Yorkshire Water Services
Developer Services
Pre-Development Team
PO BOX 52
Bradford
BD3 7AY

Your Ref: 2023/93083
Our Ref: Z005264

17th November 2023

adj 33 Arthur Street, Golcar, Huddersfield – Demolition of detached garage and erection of 1 detached dwelling, formation of car parking spaces and access, associated landscaping, reconfiguration of parking spaces and access for existing dwelling

Block Plan 1: 200

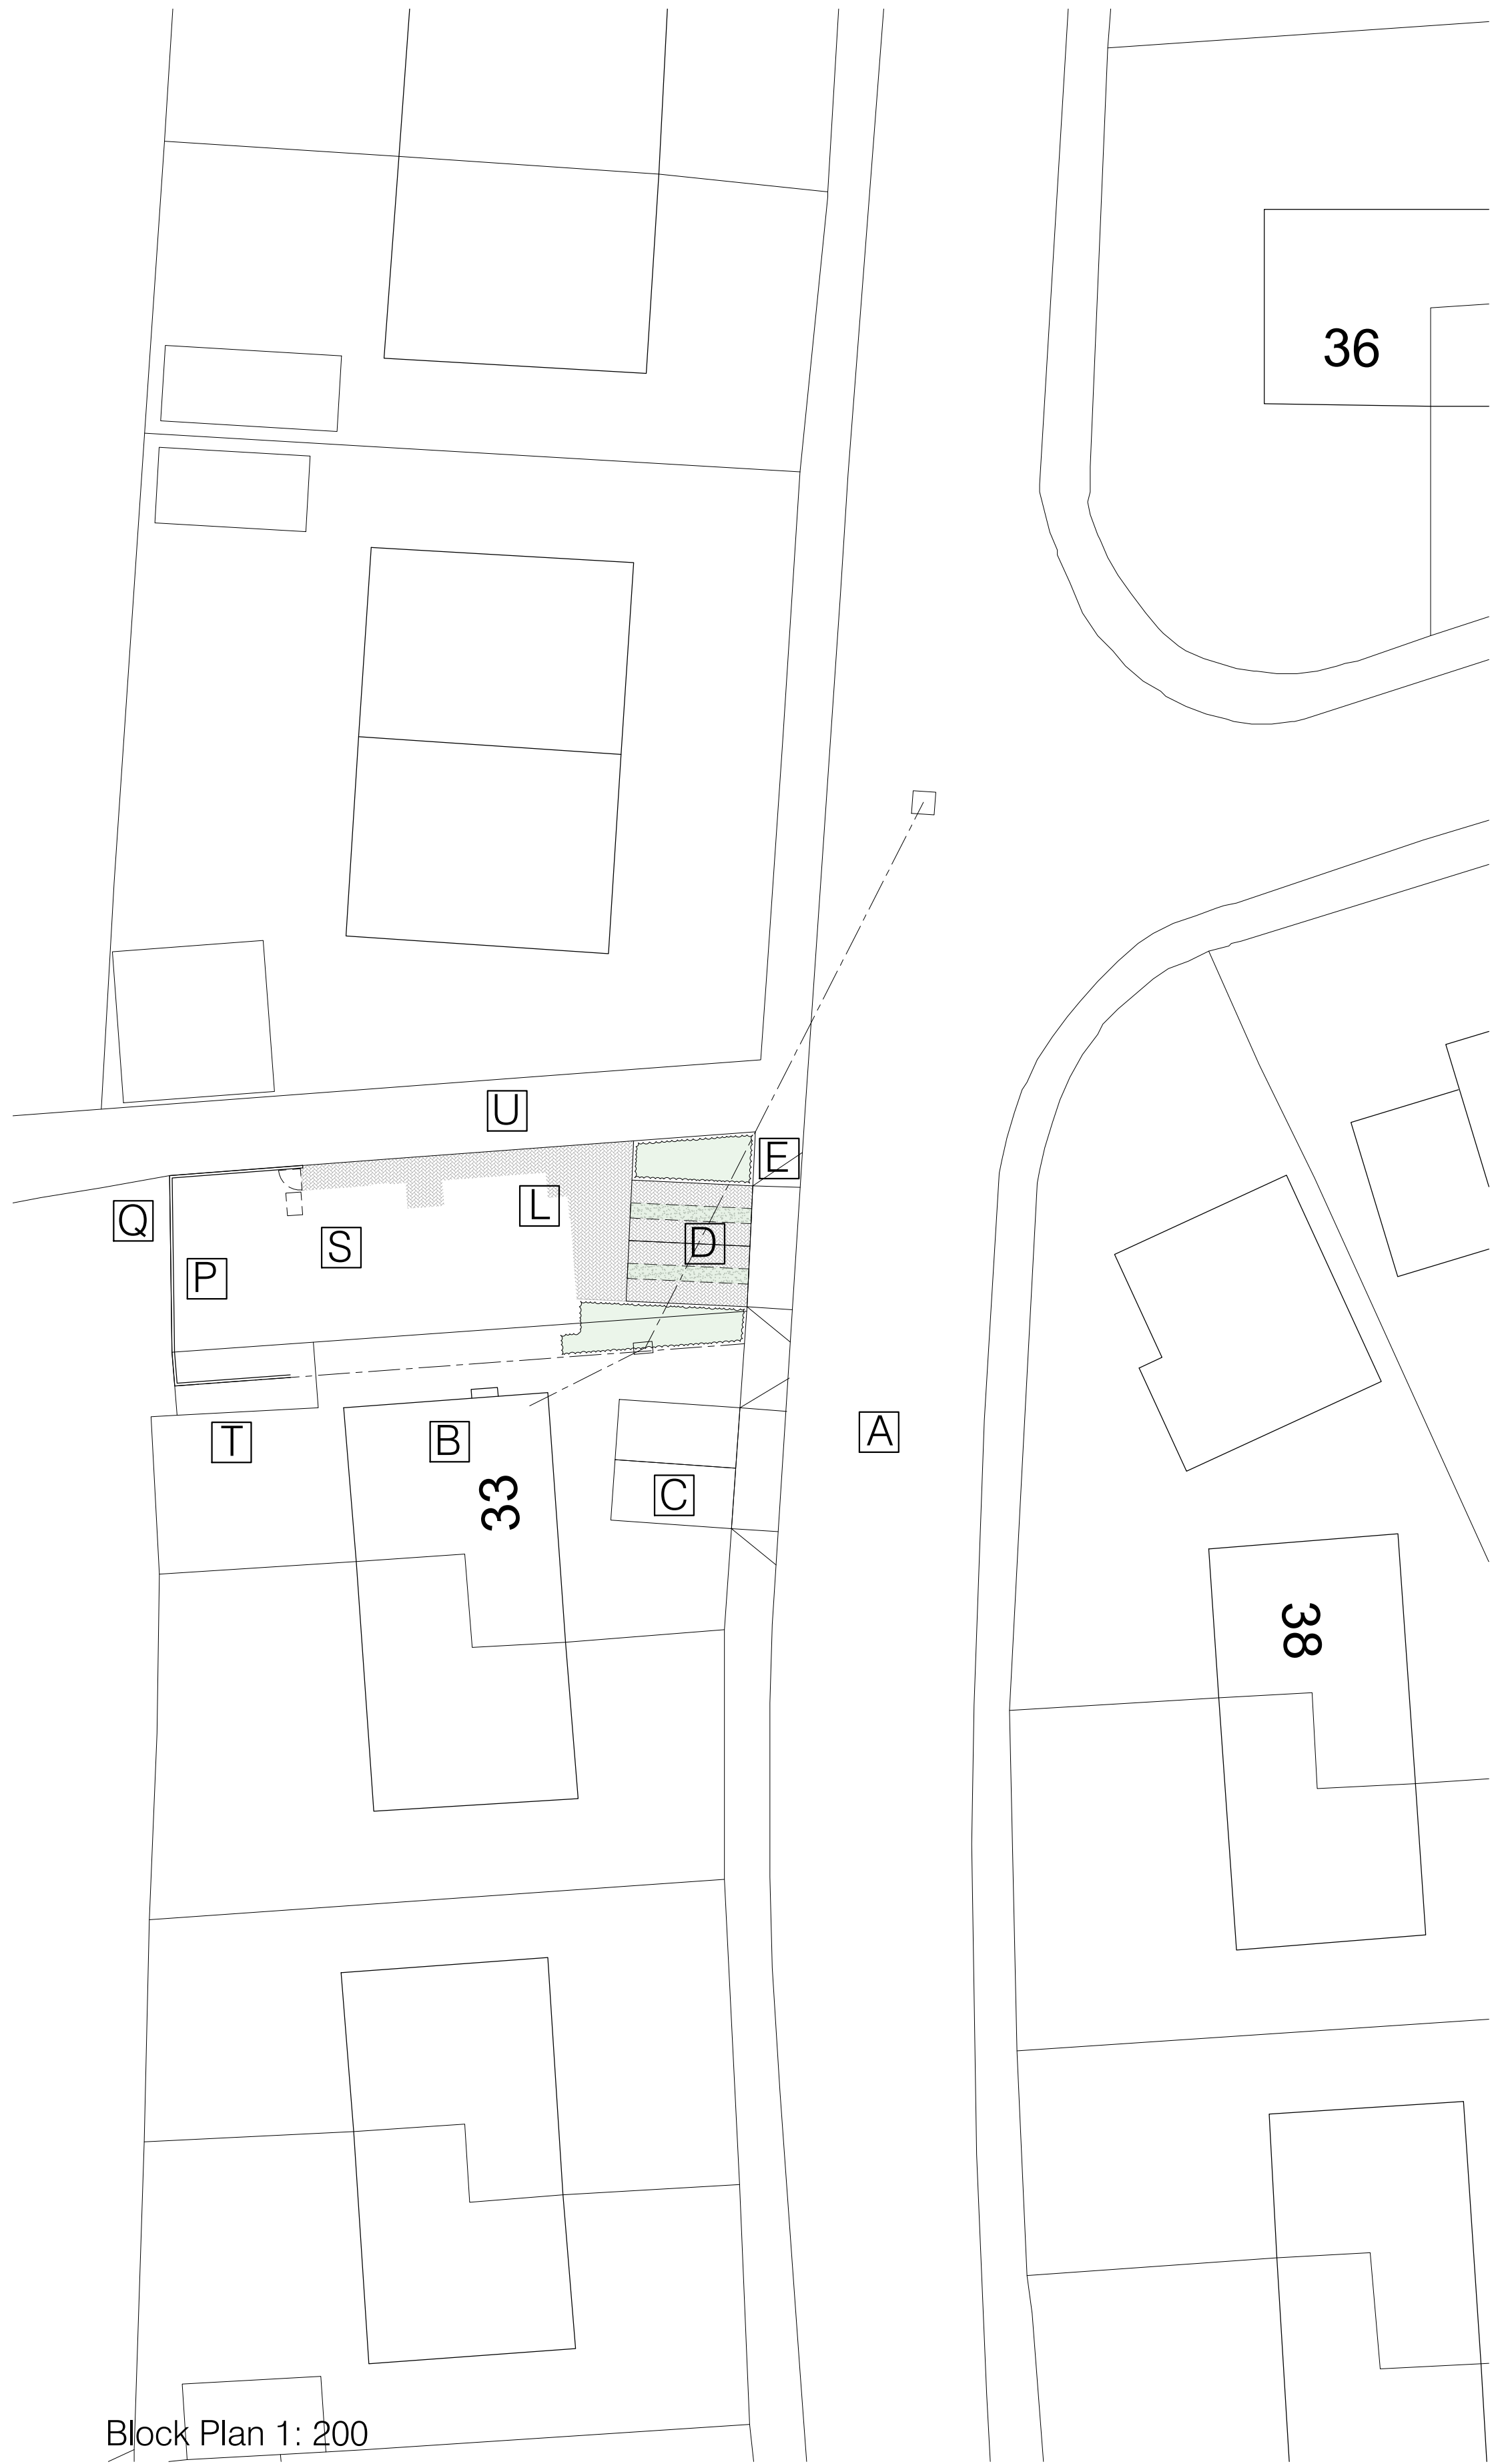
diameter public surface water sewer recorded to cross the site. It is essential that the presence of this infrastructure is taken into account in the design of the scheme. It may not be acceptable to raise or lower ground levels over the sewer and we will not accept any inspection chambers on the sewer to be built over. Nor new trees to be planted within 5 metres of the sewer.

2. Yorkshire Water has no objection to the details submitted on drawing, Plans as proposed (22137)2 (revision A) dated November 2023 prepared by JG-d Architecture and Design which shows the proposed building stand-off from public sewer centre-line (of three metres) and no trees/ soft landscaping within 5 metres of the public sewer.
